Large-scale Residential Development Appeal Observation

Case Number / Description
324275

Application reference number: WEBLRD6093/26-S3B

Please see below my observations on valid appeal/s to An Coimisiun Pleanala against the decision of Dublin City Council to grant planning permission for a proposed LRD at Milltown Park, Dublin 6.

Figure 3.7: Proposed Layout of the Subject Development with the Heights Noted

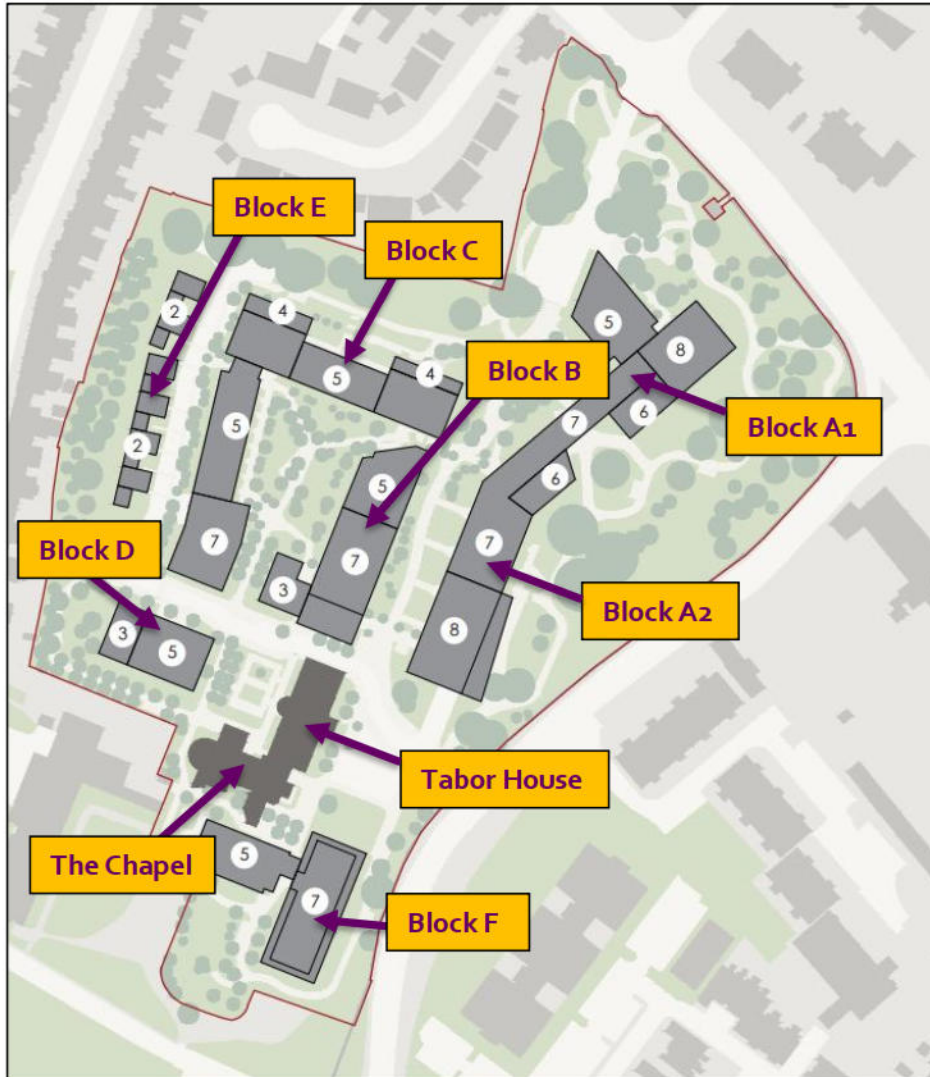
- In particular, a reduction in the height of the eight-storey portion of Block A1 should be required - to a maximum of 3 storeys.
- A reduction in the height of the 5 storey portion of Block A1 - to a maximum of 3 storeys.

Figure 3.10: Block A Massing Strategy

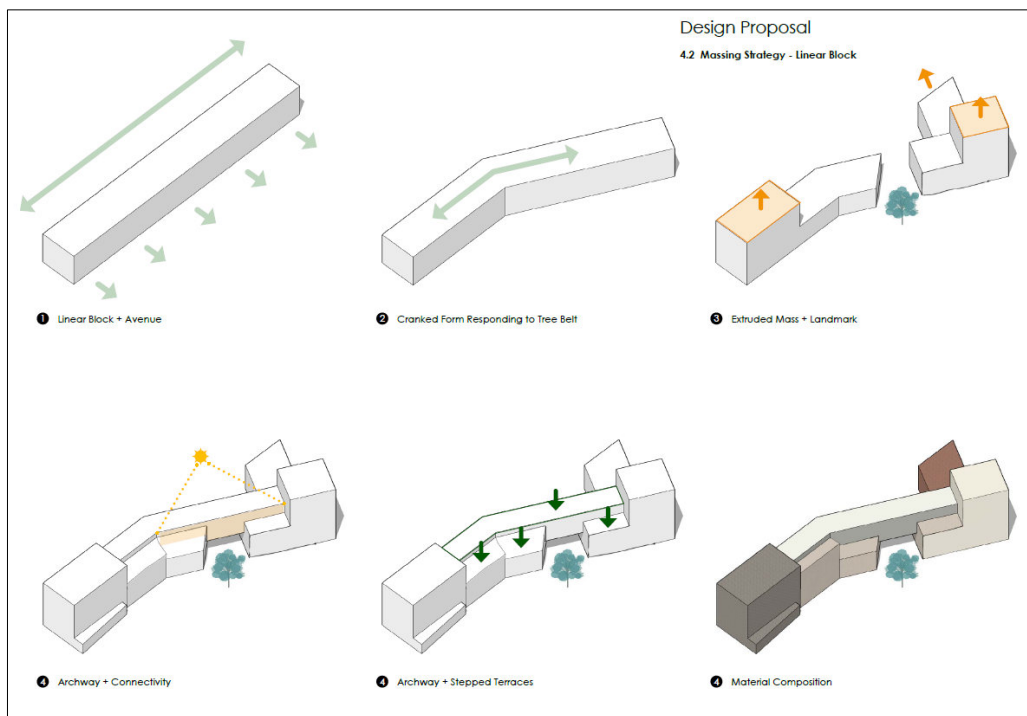
- To minimise the monolithic *soviet-style* presentation of the buildings when viewed from Norwood Park, changes should include very significant reductions in the height of buildings on site, along with *tapering* of building heights towards boundaries with existing dwellings in Norwood Park.

- Consideration should be given to the roof garden proposed for the five-storey portion of Block A1. This should be removed, to prevent overlooking on properties at nos. 1 to 5 in Norwood Park.

- On-site mature woodland and trees adjacent to Milltown Road, Sandford Road and Norwood Park should be conditioned for retention.
- The proposed red colour to the exterior of the 5 storey portion of block A1 is very obtrusive and we, in Number 3 Norwood Park, would be looking out directly at this block, as well as the 8 storey block. I would ask that the 5 and 8 storey blocks in particular, and others, be required to be finished in a less obtrusive colour - e.g. a pale grey or sand colour.
